# **ARUNDEL WAY NEIGHBOURHOOD ASSOCIATION**

### **SUBMISSION TO NWRL RE ROBERT ROAD CHERRYBROOK**

### **OBJECTION TO ENVIRONMENTAL IMPACT STATEMENT 2.**

**Application number: (SSI-5414)**

Figure 6.12 Cherrybrook Station - Indicative vehicle and pedestrian movements

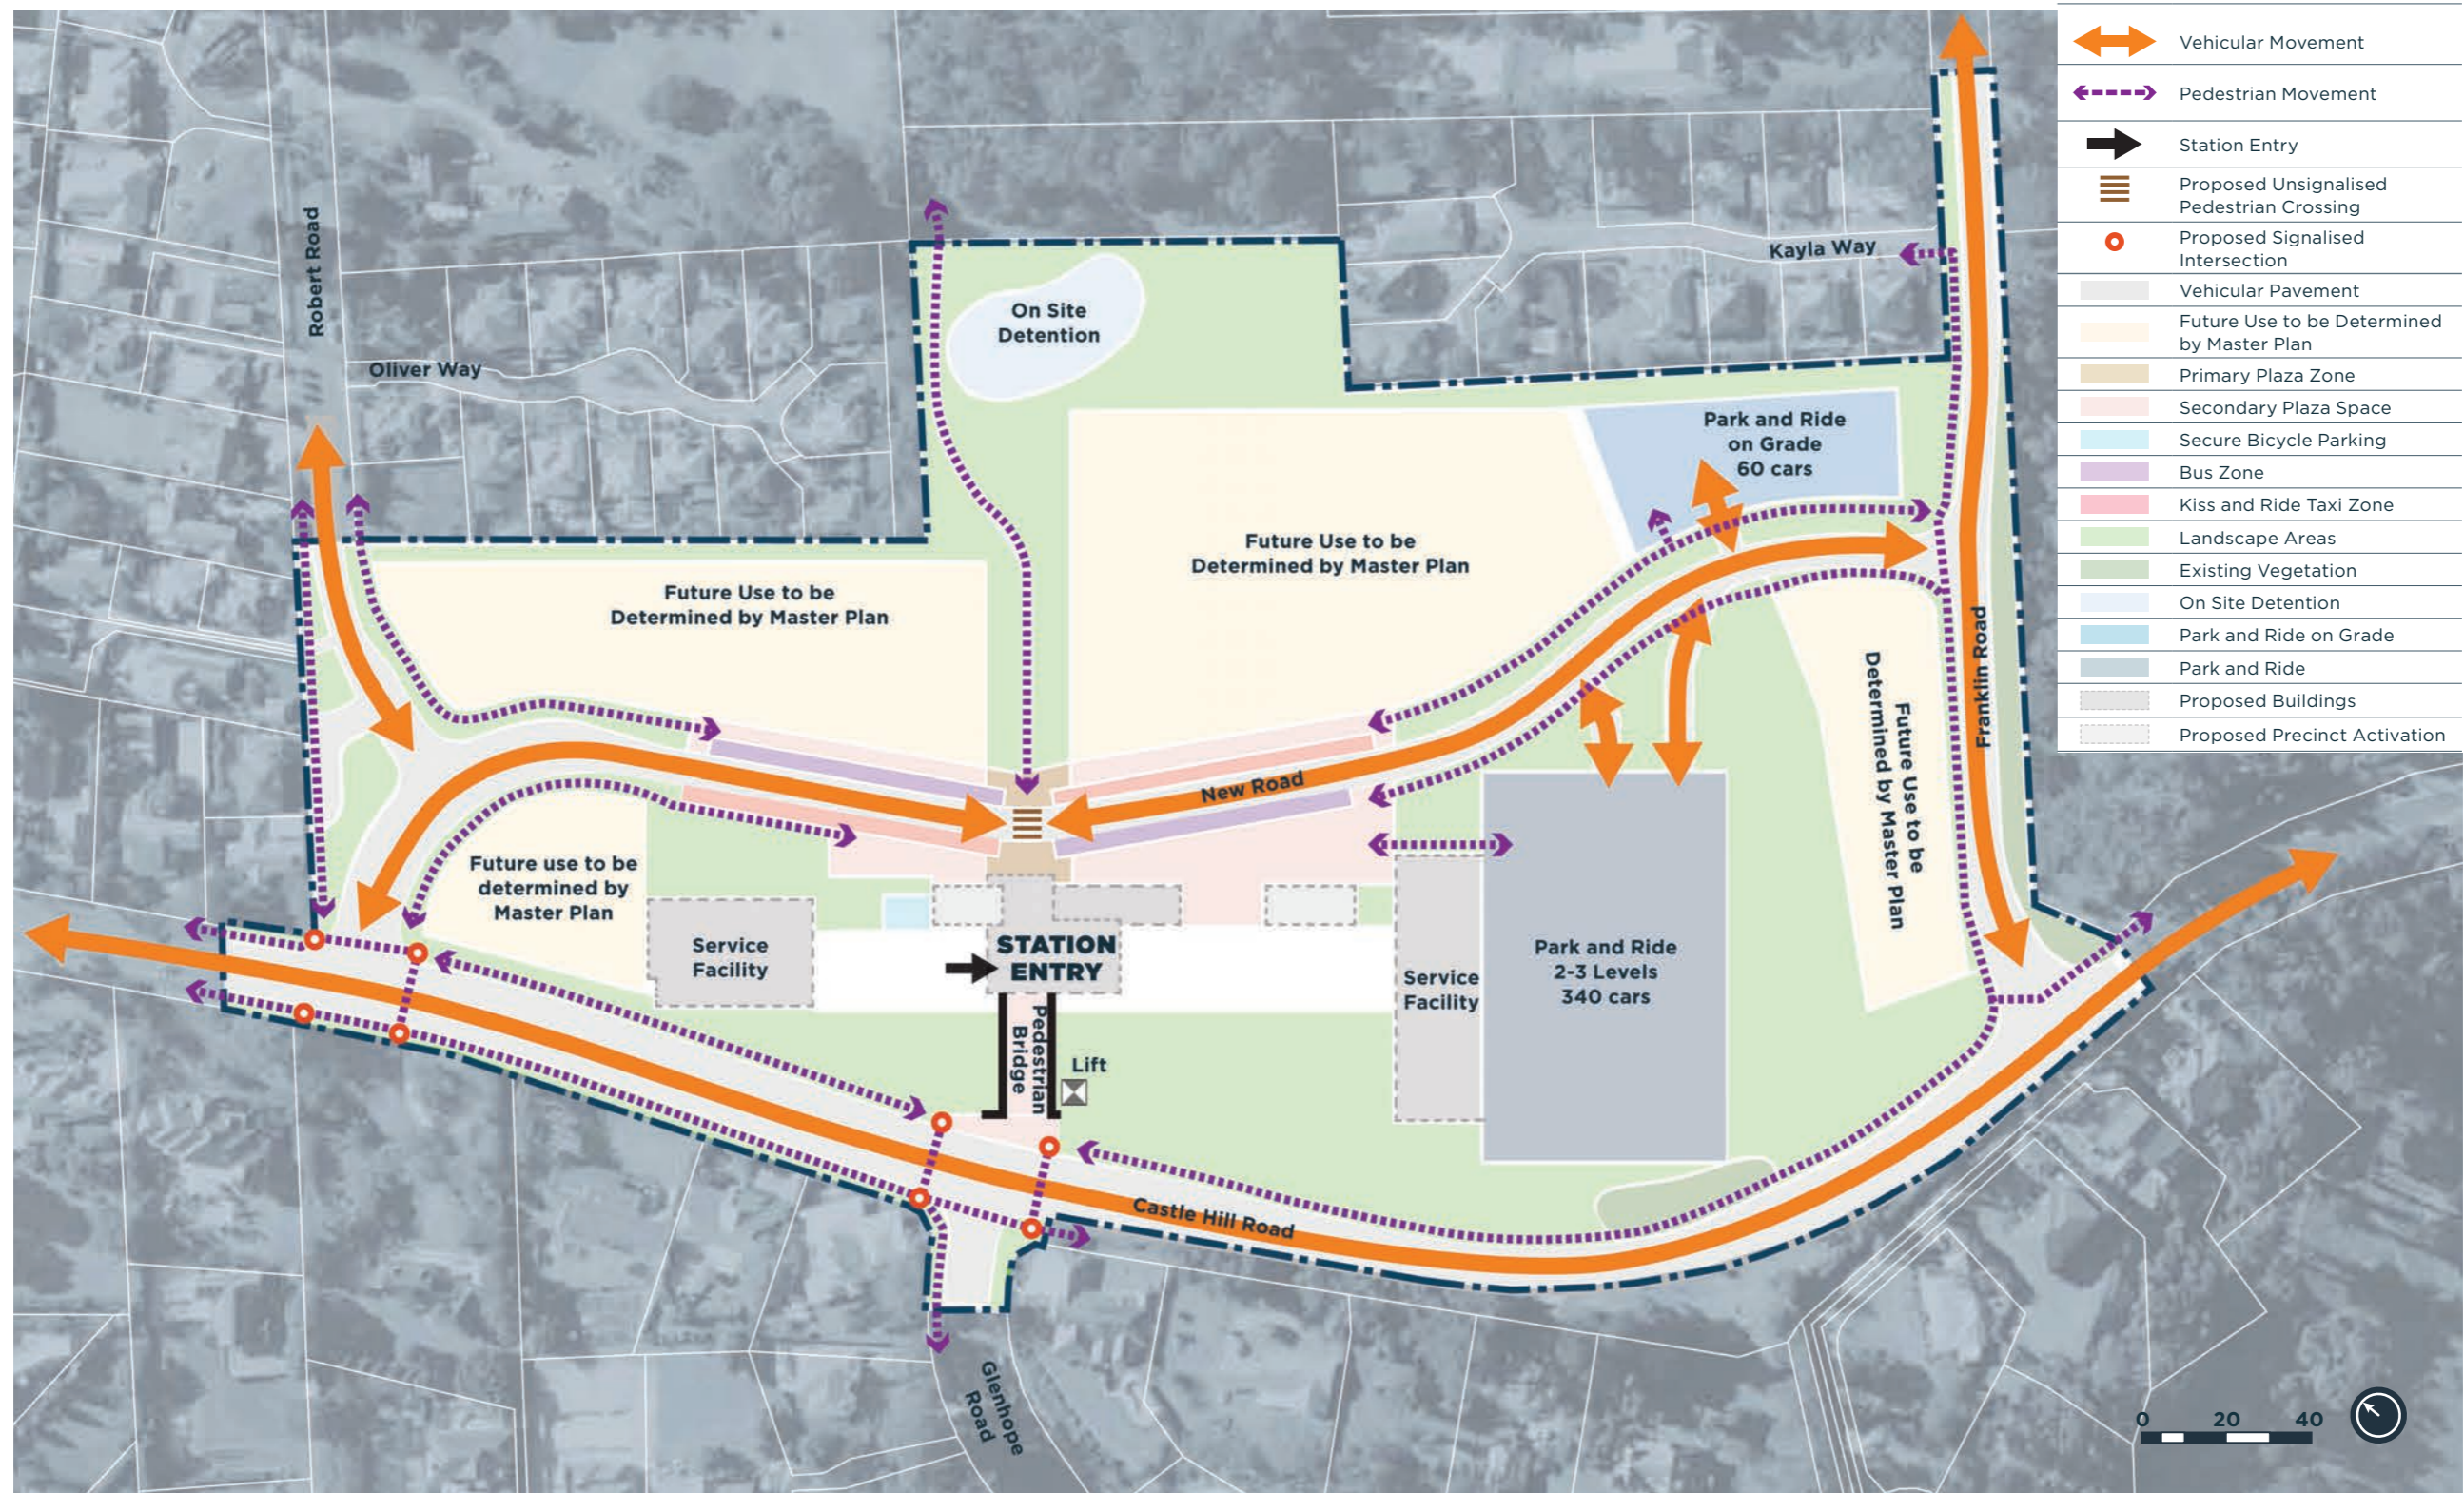
**The Arundel Way residents wish to strongly object to Robert Road being used as a feeder road to the yet to be constructed Cherrybrook Railway station.**

**Specifically we object to public transport, notably buses, using Robert Road to access the new station.**

- 1. Robert Road is a narrow road designed for low numbers of vehicles. It is not designed for heavy traffic, particularly large vehicles such as buses.**

- 2. The absurdity of the proposal to use Robert Road is further highlighted by the more sensible option of using County Road and then Castle Hill Road. County Drive is clearly designed for heavy traffic. Robert Road is not. We therefore propose that buses heading south on County Drive continue and turn left into Castle Hill Road and head towards Cherrybrook station, instead of the NWRL proposal of buses heading south on County Drive turn left into John Road and right into Robert Road and then south into Robert Road and onto Cherrybrook Station.**

**4. Safety issues are paramount. Robert Road is a quiet street, with pedestrians crossing the road at many points, and often, to get access to the park at the corner of Dalkeith Road. No pedestrian crossing exists.**

**5. Cars existing Arundel Way will not be able to exit safely. The increased traffic of large vehicles will obstruct vision. This also applies to residents of other cul-de-sacs off Robert Road such as Louise Way and Oliver Way. Accidents are bound to happen with the toxic combination of large vehicles and a narrow street.**
